Date 22 November 2021
Our Ref 21/01810/FLH

Town and Country Planning Act 1990 (As Amended)
19 Derek Avenue, West Ewell, Epsom
Garage conversion

PROPOSED ELEVATIONS

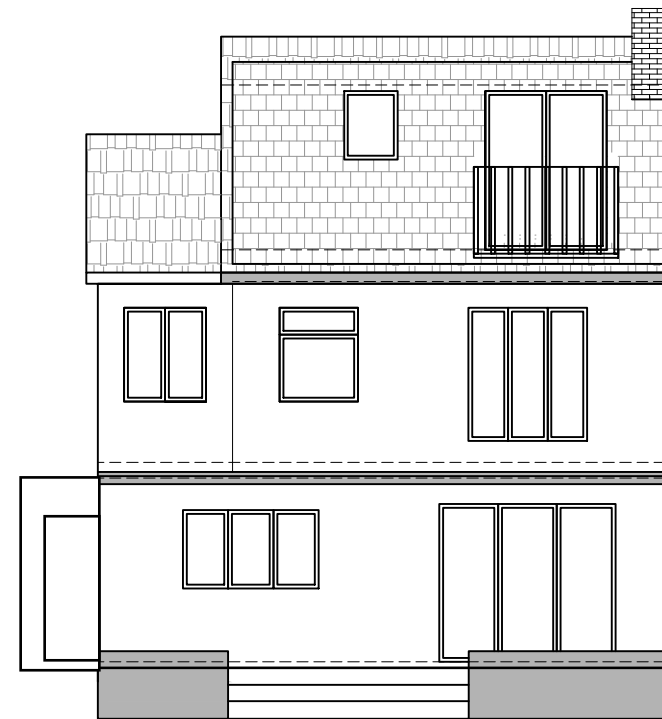
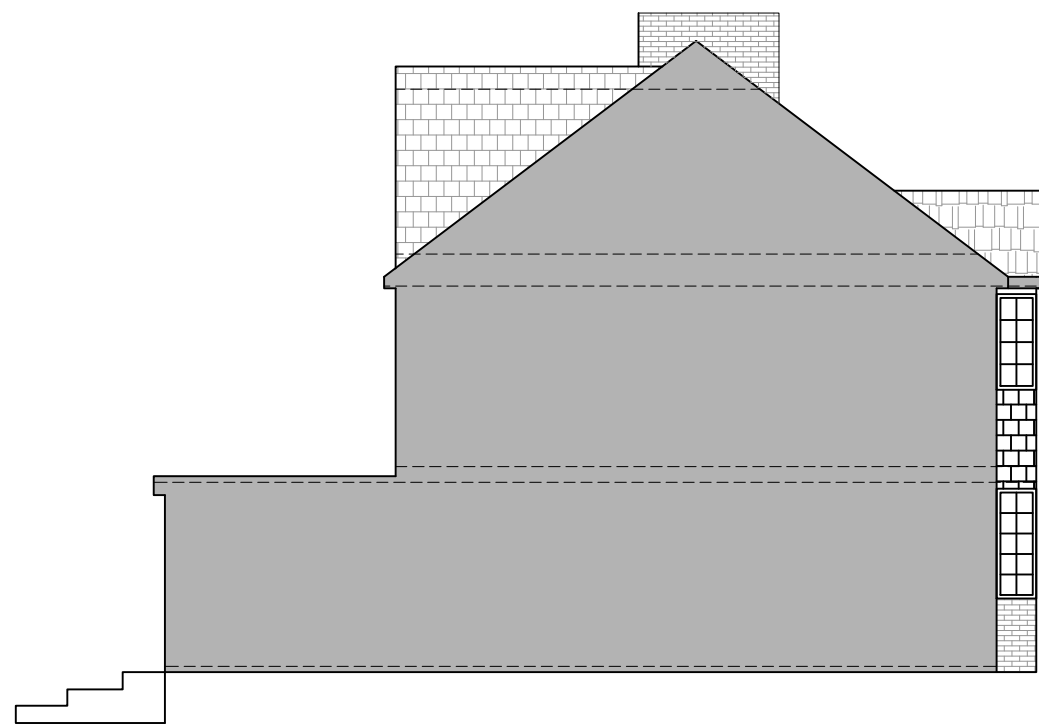
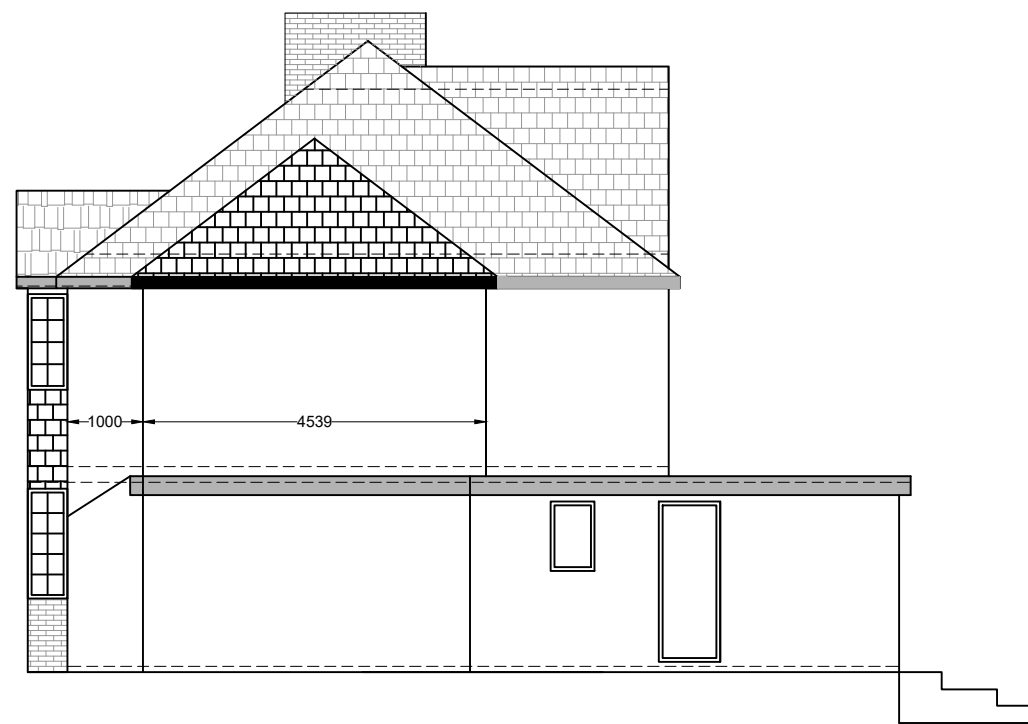
1 The proposal description in the application form states "garage conversion". This is not considered to fully describe the proposed works. The submitted drawings show a first floor side extension. Please confirm you wish this first floor side extension to be included within the proposal description and assessed as part of this application?
